City of Portland, Maine - Building or Use Permit Application
 389 Congress Street, 04101 Tel: (207) 874-8703, Fax: (207) 874-8716

Permit No: 06-1157	Issue Date:	CBL: 299 D046001
------------------------------	--------------------	----------------------------

Past Use: Governmental/ Riverton School	Proposed Use: Riverton School- build an addition & renovations of the existing structure	Permit Fee: \$27,020.00	Cost of Work: \$2,699,644.00	CEO District: 5
Proposed Project Description: Riverton School- build an addition & renovations of the existing structure		FIRE DEPT: <input type="checkbox"/> Approved <input type="checkbox"/> Denied	INSPECTION: Use Group: Type	
		Signature:	Signature:	
PEDESTRIAN ACTIVITIES DISTRICT (P.A.D.)				
Action <input type="checkbox"/> Approved <input type="checkbox"/> Approved w/Condition <input type="checkbox"/> Denied				
Signature: Date:

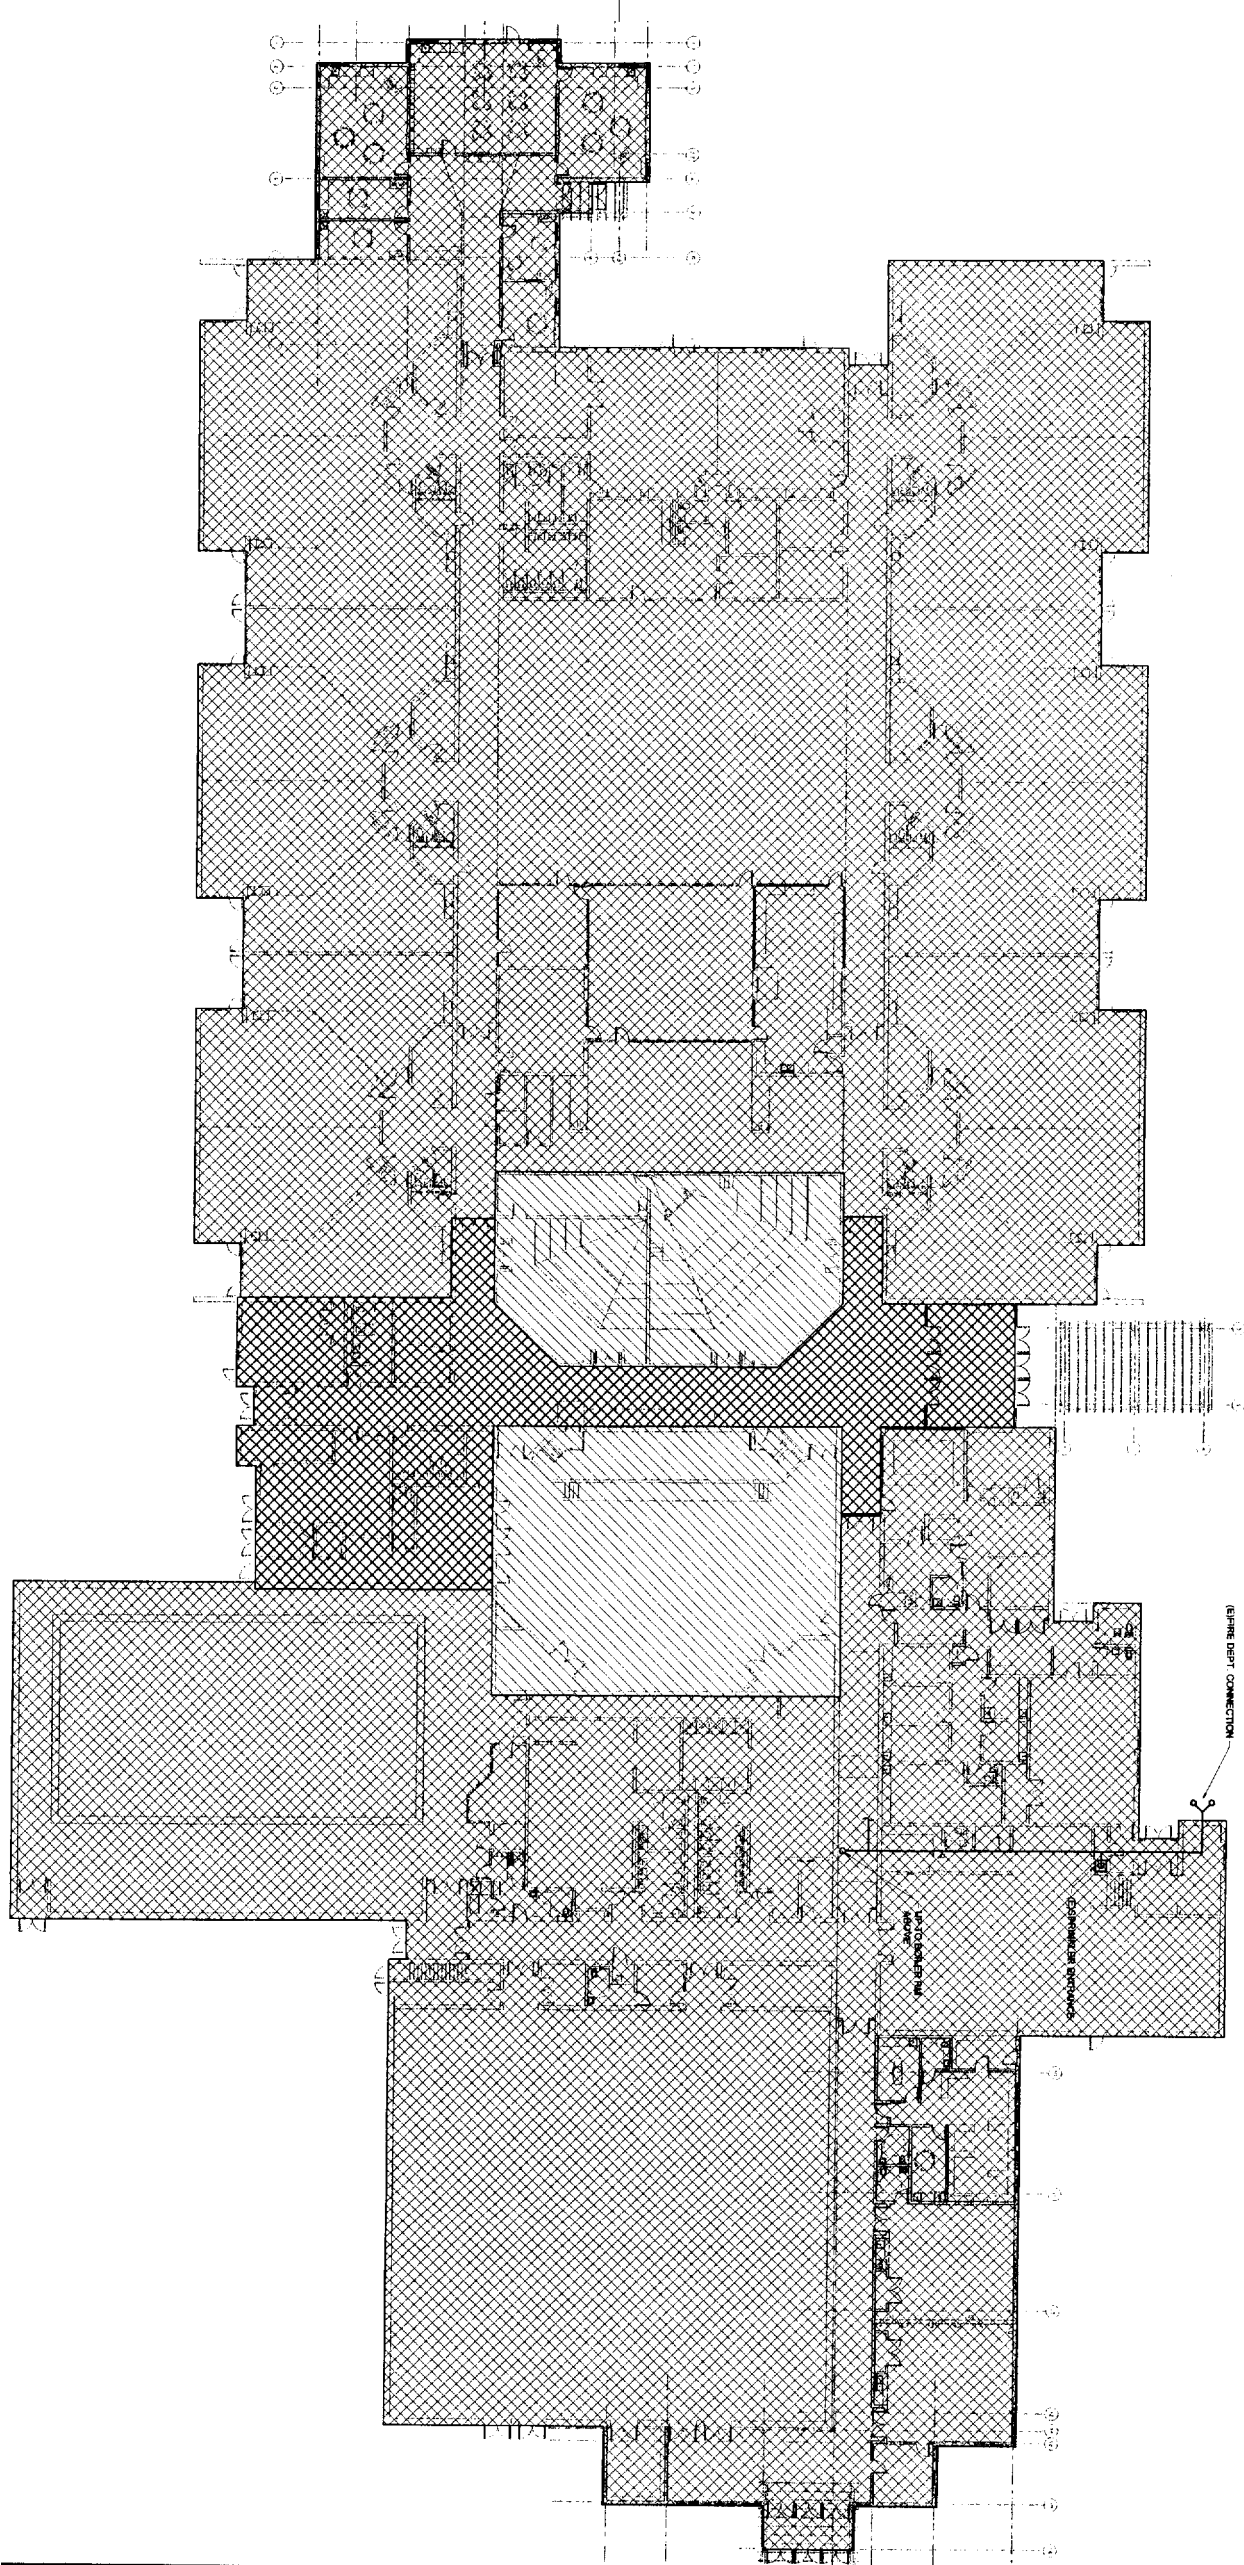
A) Because the construction documents offer several levels of Fire Suppression alternatives, which one is the one that was finally selected?

1) Who was the staffer from the State Fire Marshall's office who reviewed the plans and what was their final specific direction regarding fire suppression.

2) What was Captain Cass's final requirement with regard to fire suppression systems.
